Re: Aldi Distribution Centre – MP05_0142-Mod-2

Thank you for providing Liverpool City Council with the opportunity to provide comment on the proposed modifications at the Aldi Distribution Centre, 10 Burando Road, Prestons.

PROPOSED OVERALL SITE PLAN
CAR PARK EXTENSION

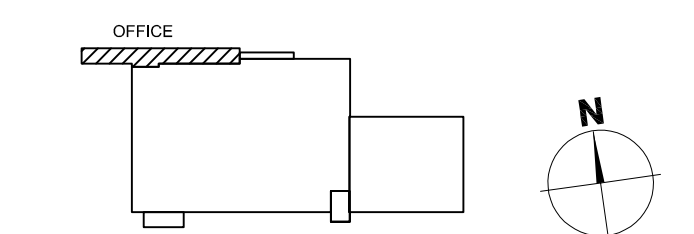
The proposed development will result in increased hardstand area for parking, and the site has been identified as being affected by flooding (low/medium risk category). As a result, there may be adverse effects upon downstream properties due to changes to the pervious areas on site. Therefore, consideration should be given to ensuring that the development will not result in adverse flood affectation and stormwater run-off within the vicinity.
